FIRST FLOOR PLAN
SCALE: 1/4" = 1'-0"

APPROVED
Limited liability only. Owner/Builder responsible for field compliance with the code.

02/10/2022

FIRST FLOOR PLAN
SCALE: 1/4" = 1'-0"

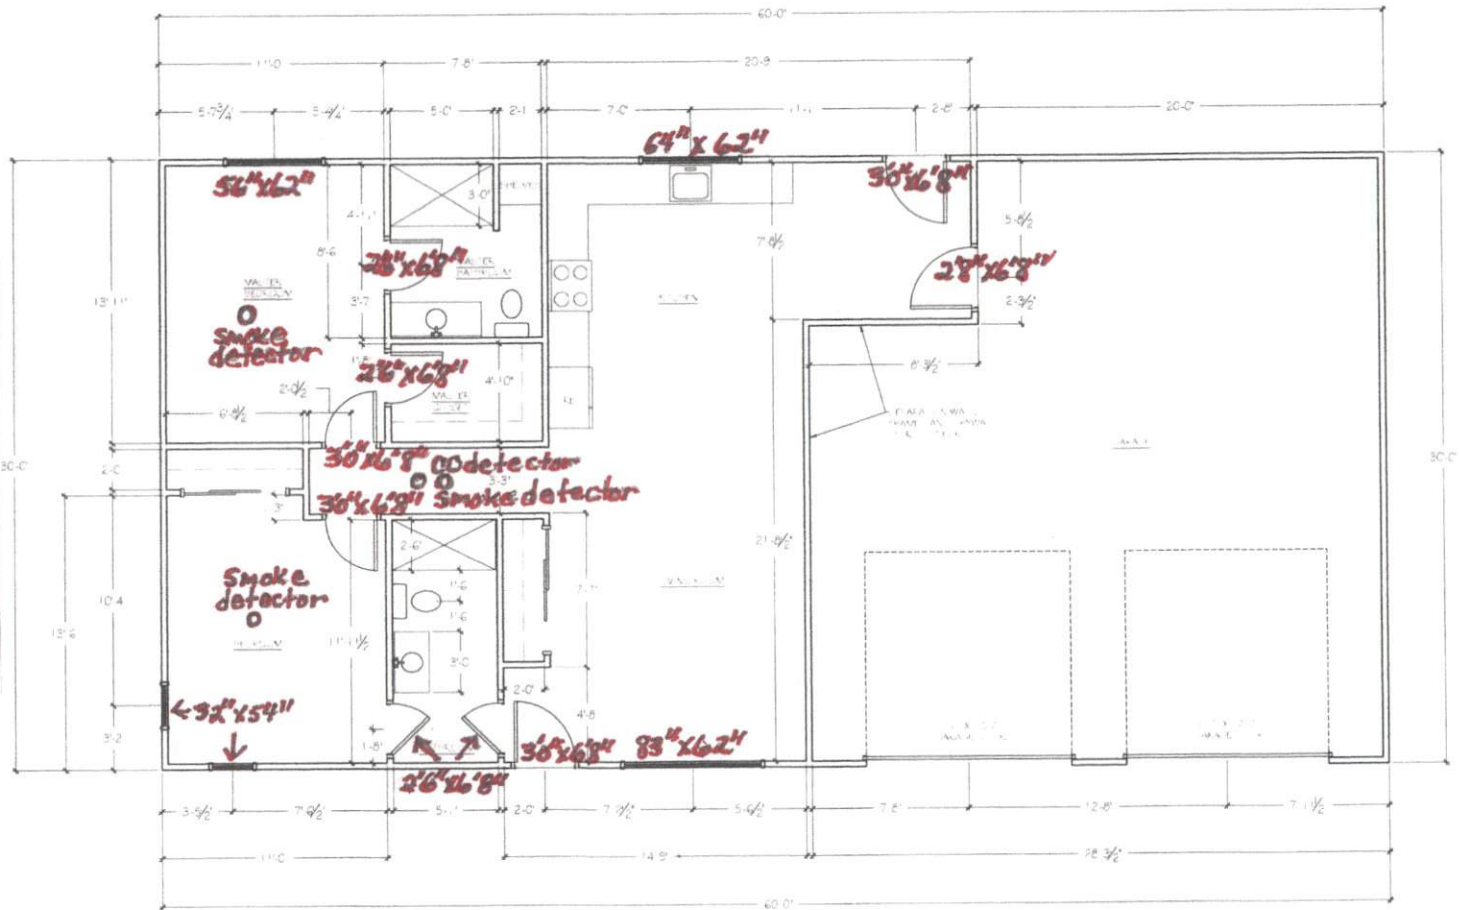
Bedroom windows must meet NCRC R310. a 54 inch window may not meet these requirements, depending upon the window manufacturers design. This will need to be field verified.
